**Consultation Response from KC,
Lead Local Flood Authority**

2024/93189 Unit 19-20, Headfield Mills, Savile Road, Savile Town, Dewsbury, WF12 9LQ

Erection of single storey extension, external alterations to shopfront to front and side elevation, change of use of part vacant area into class E Cafe and formation of car park access

Date Responded: 22nd March 2026

Drawing title  
PROPOSED CAR PARK LAYOUT

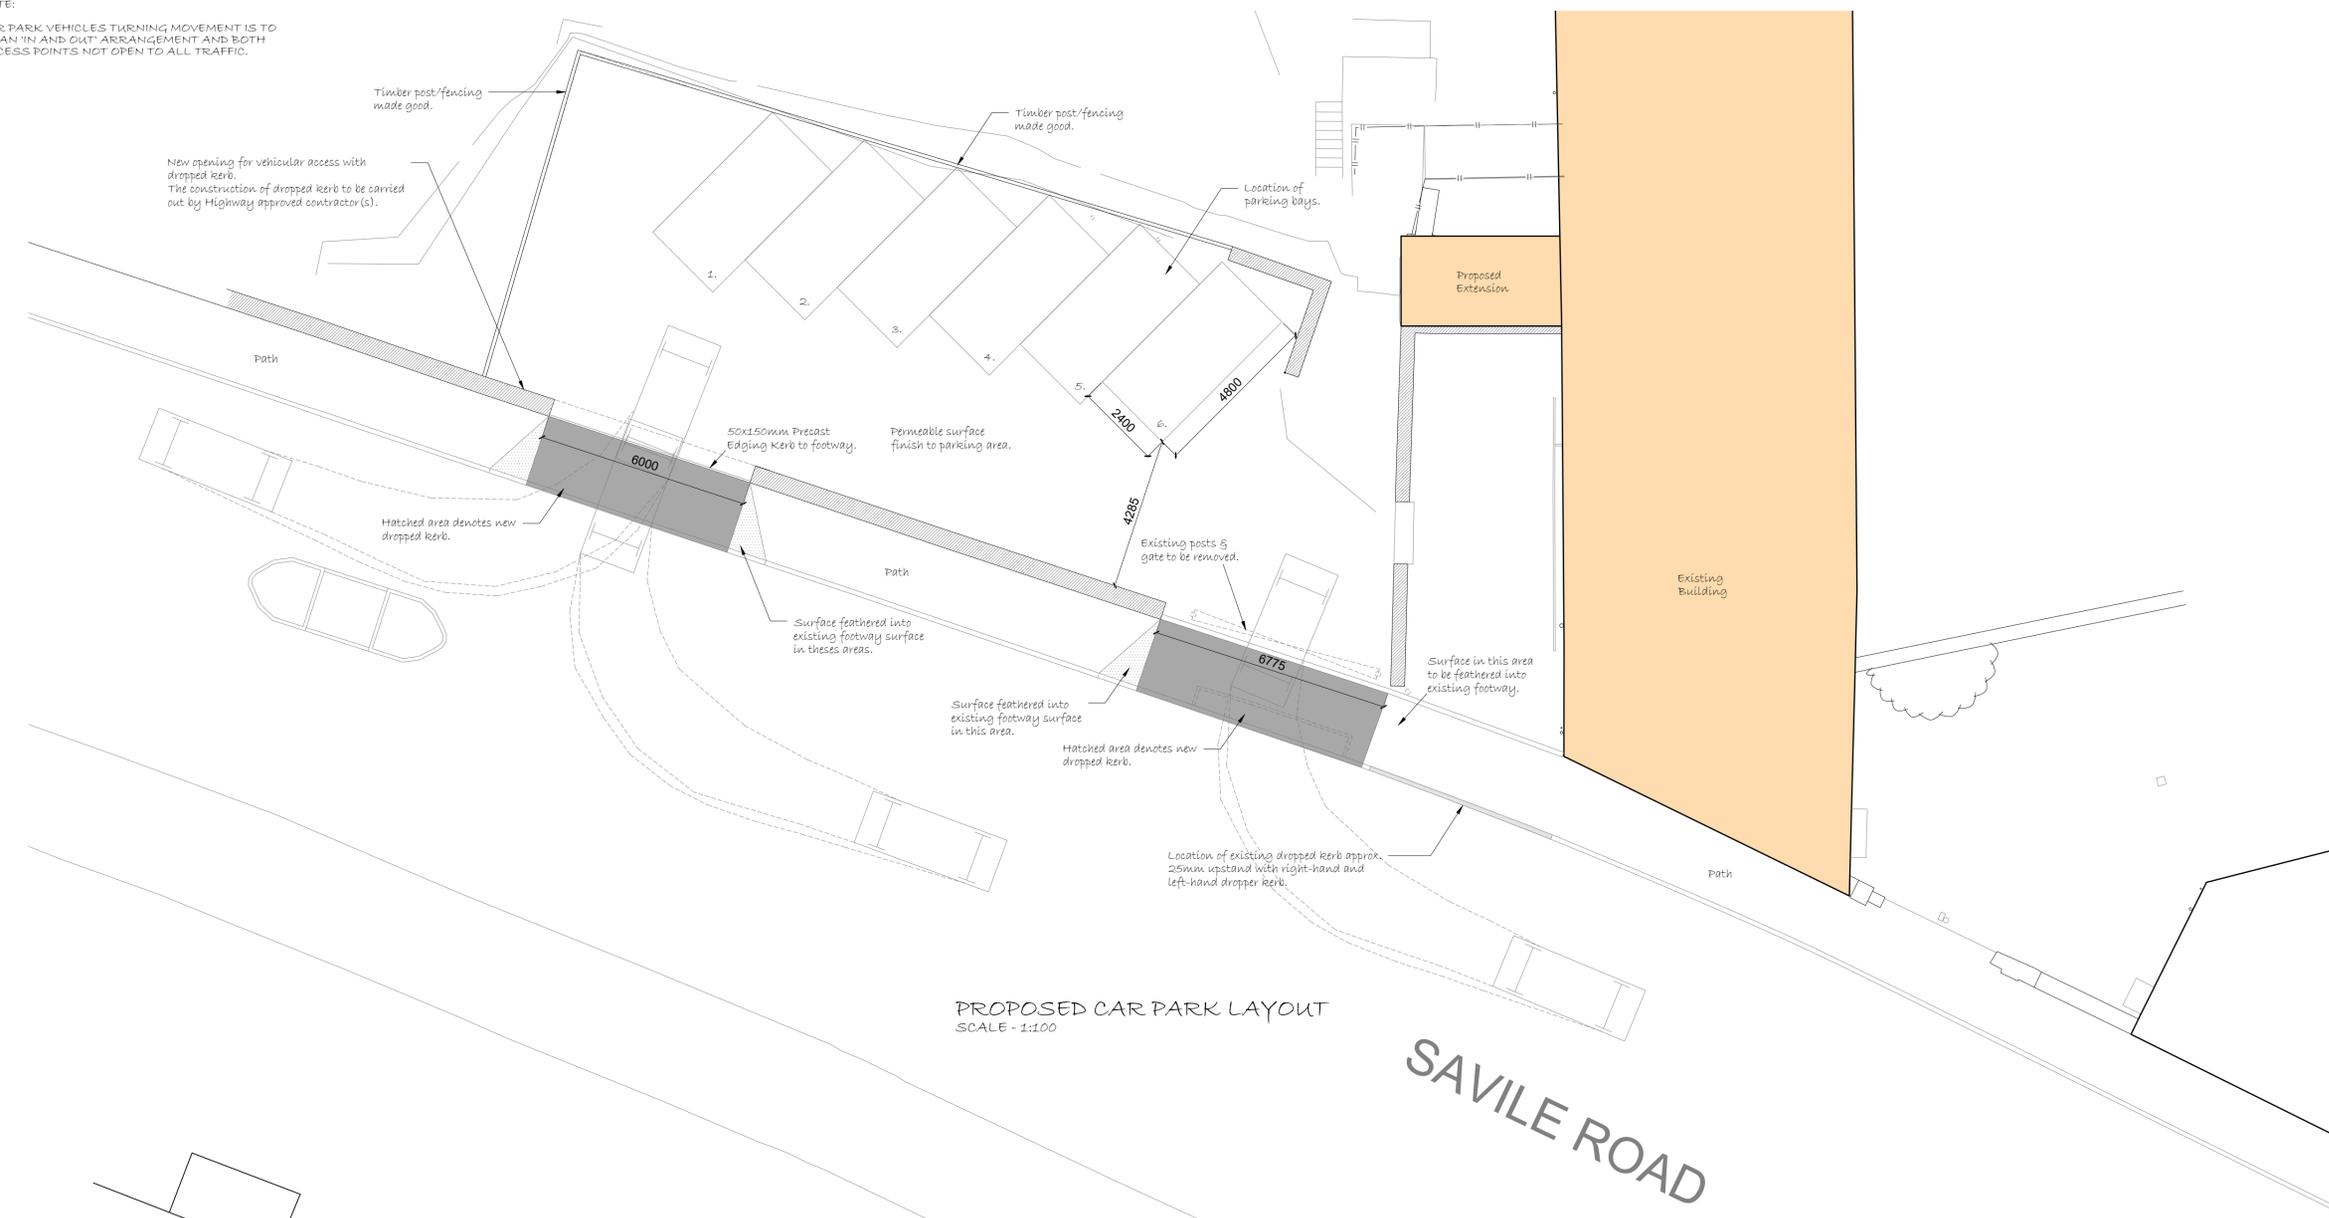
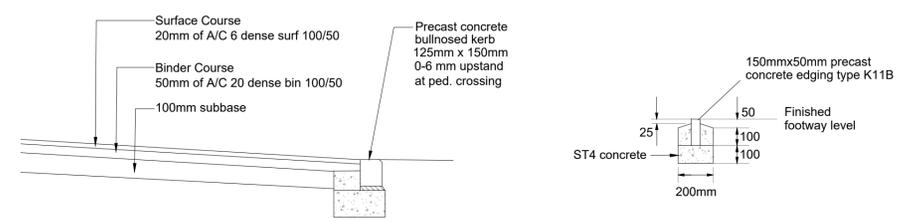
The use of car parking area is small and, in this instance, would not benefit from attenuation.
